From: Sue Howell
Sent: 11 January 2018 14:33
To: Planning.Responses
Cc: David Easton
Subject: RE: Planning Consultation on LY/24/17/DOC

Comment from Greenspace

From the details submitted we **confirm that we recommend the discharge of Condition 16** on application LY/24/17/DOC imposed under application LY/9/17/PL.

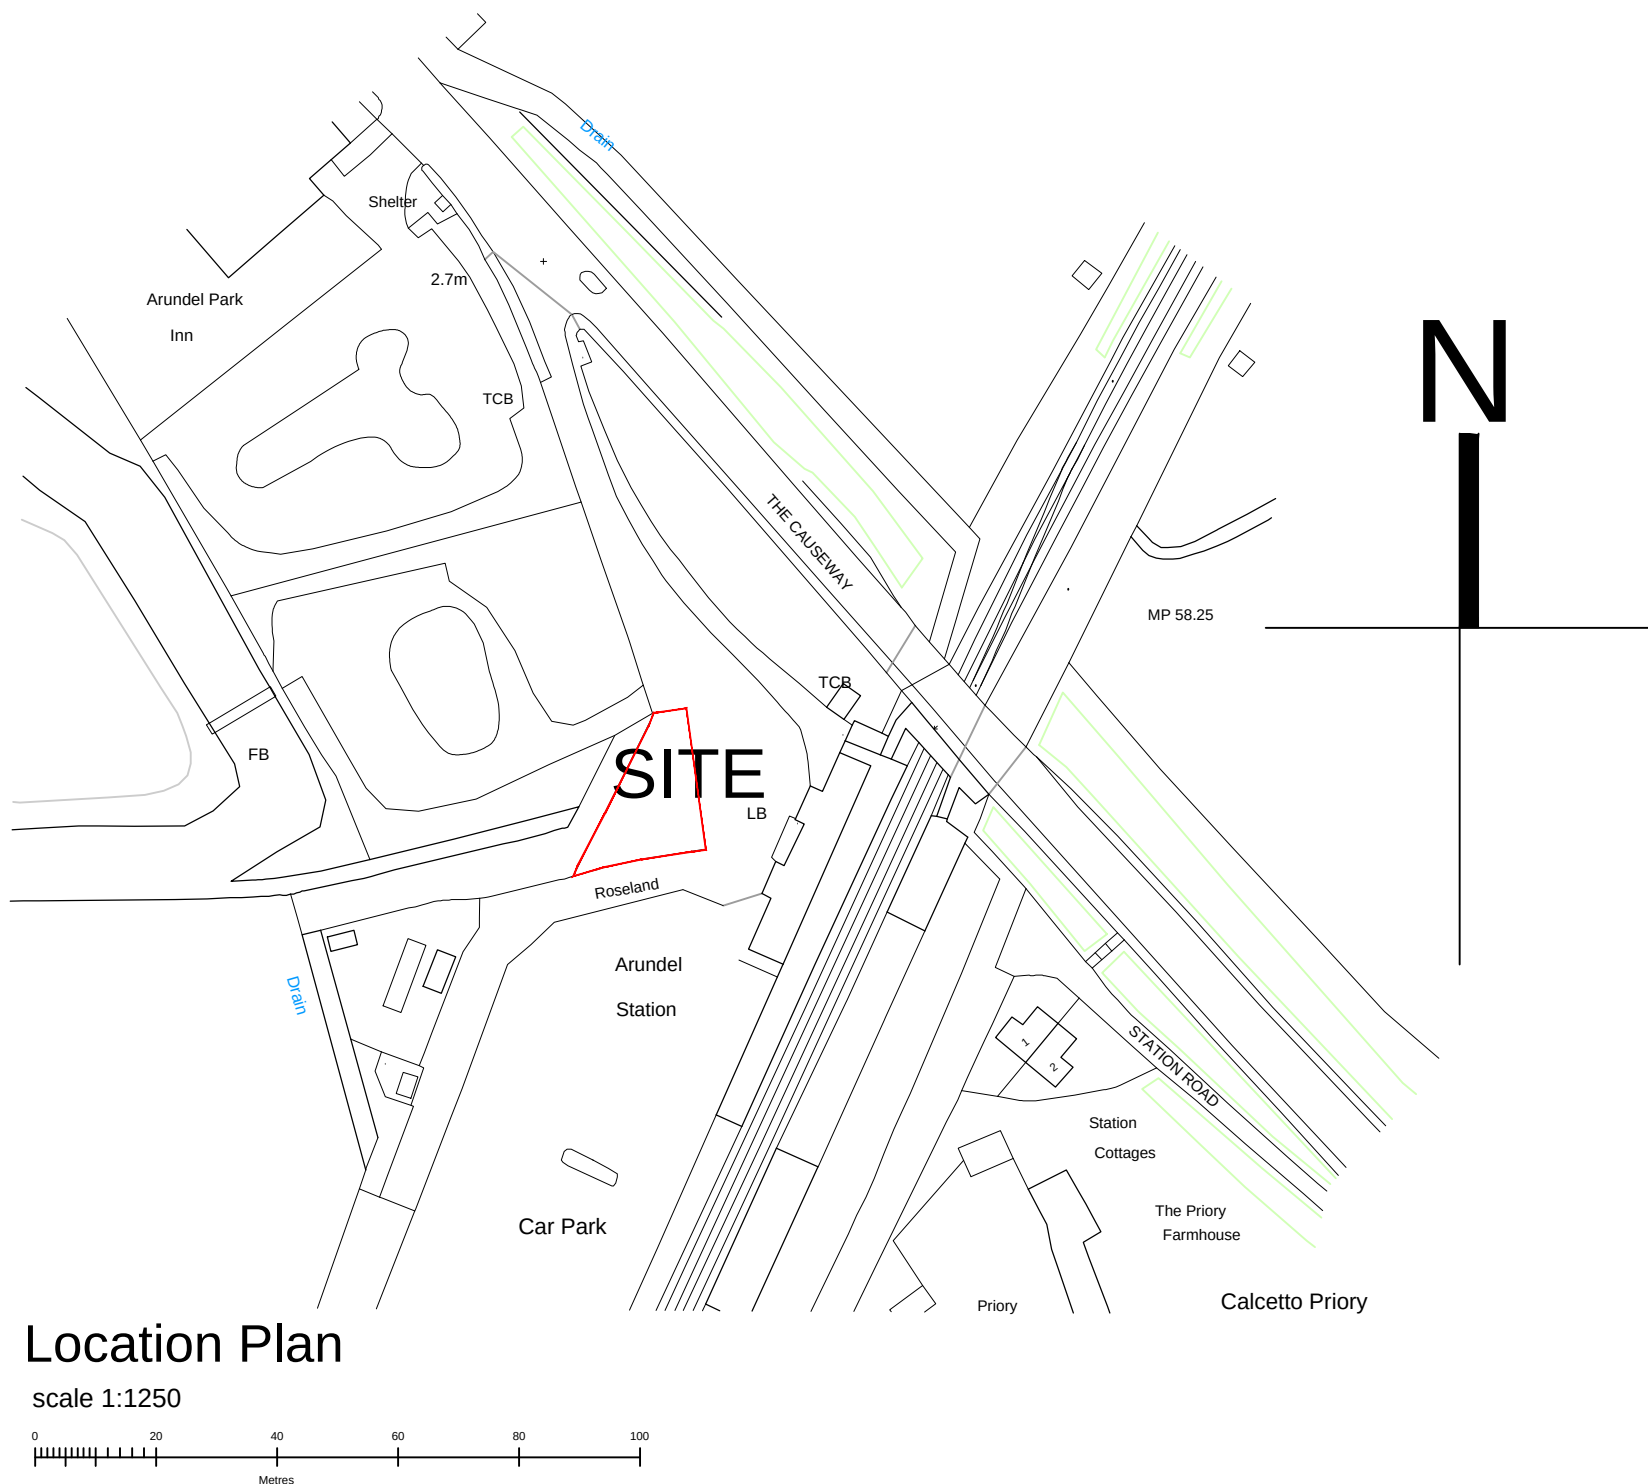
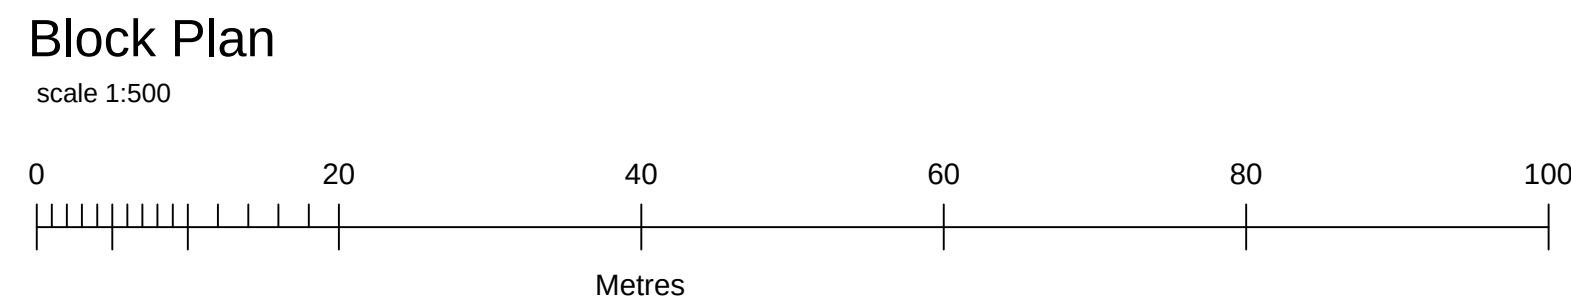
Further to submission of drawing 1701/PL/03 Rev C, I would consider that the existing beech hedging and existing tree are providing suitable landscaping to be retained and fit for location, we would therefore not require any addition in this instance.
